Lighthouse Green Fuels - EN0110025

LGF Projects Limited

Section 51 advice regarding draft application documents

Issued on 1 July 2026

Inset 4.2 SAF production process

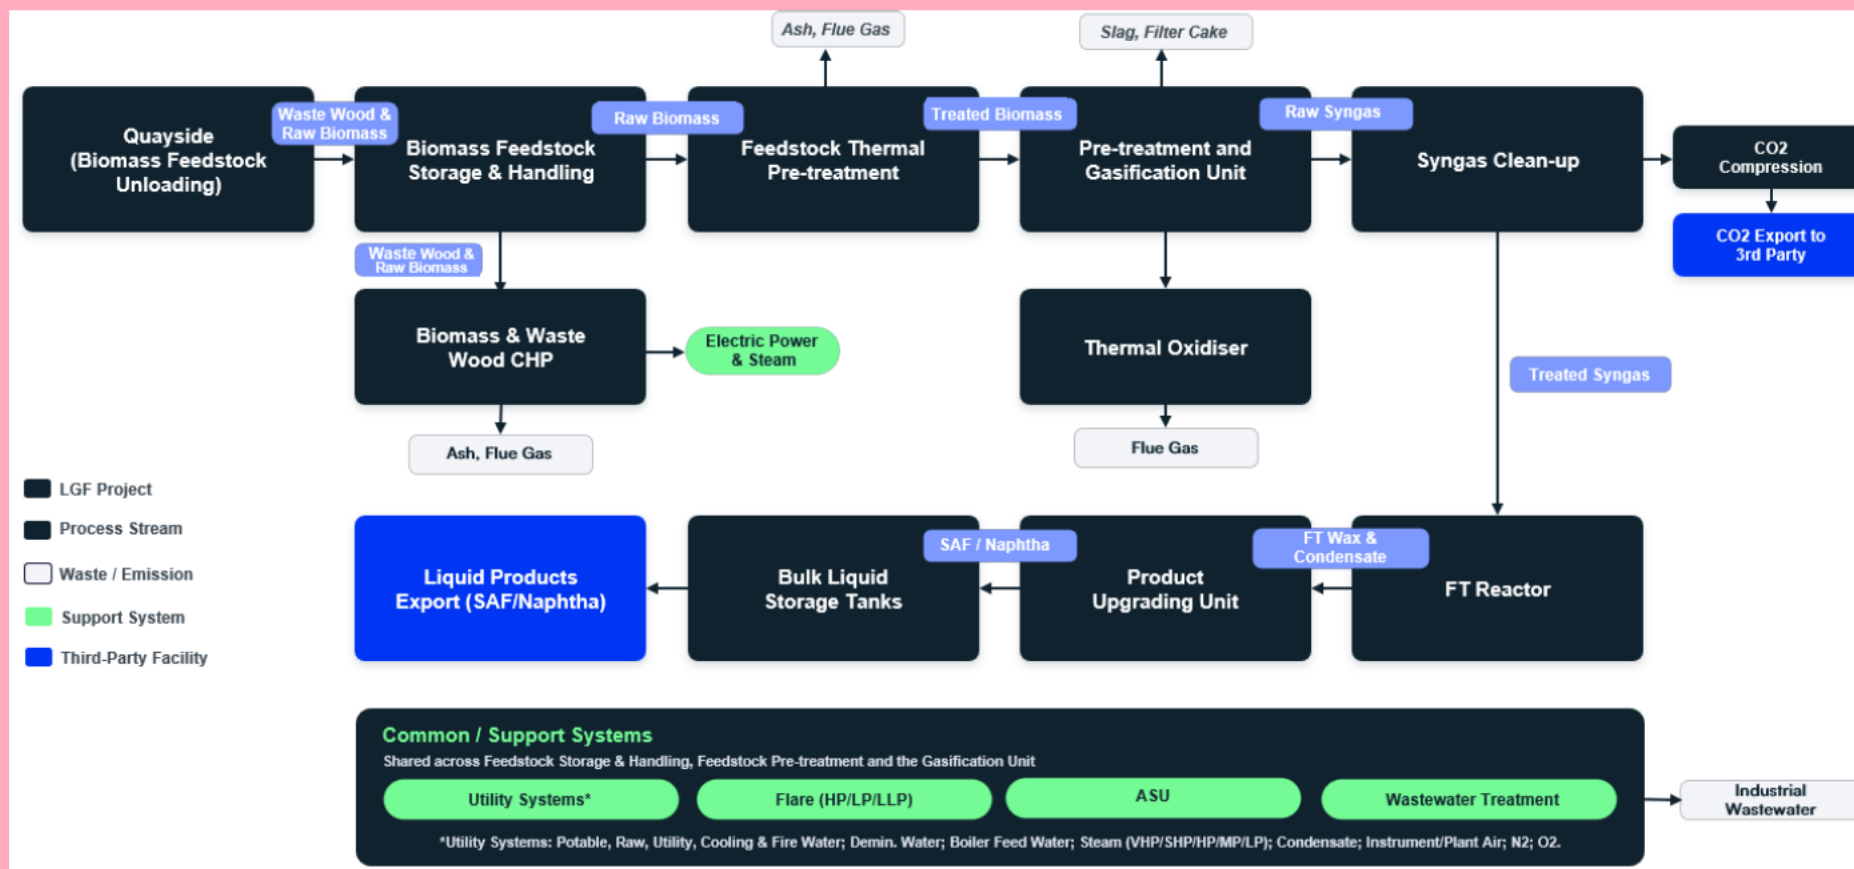
6.	Inset 4.2	We consider this diagram could be improved to further clarify the production process: • more detail should be added to the biomass and waste wood CHP and on feedstock pre-treatment, including inputs and outputs such as waste residues and emissions • clarification should be provided on SAF processing, including inputs and outputs at different stages • utility systems, flares, waste water and the air separation unit are listed but have not been incorporated into the process diagram. Taking an input – output approach would contextualise these elements of the development within the production process.
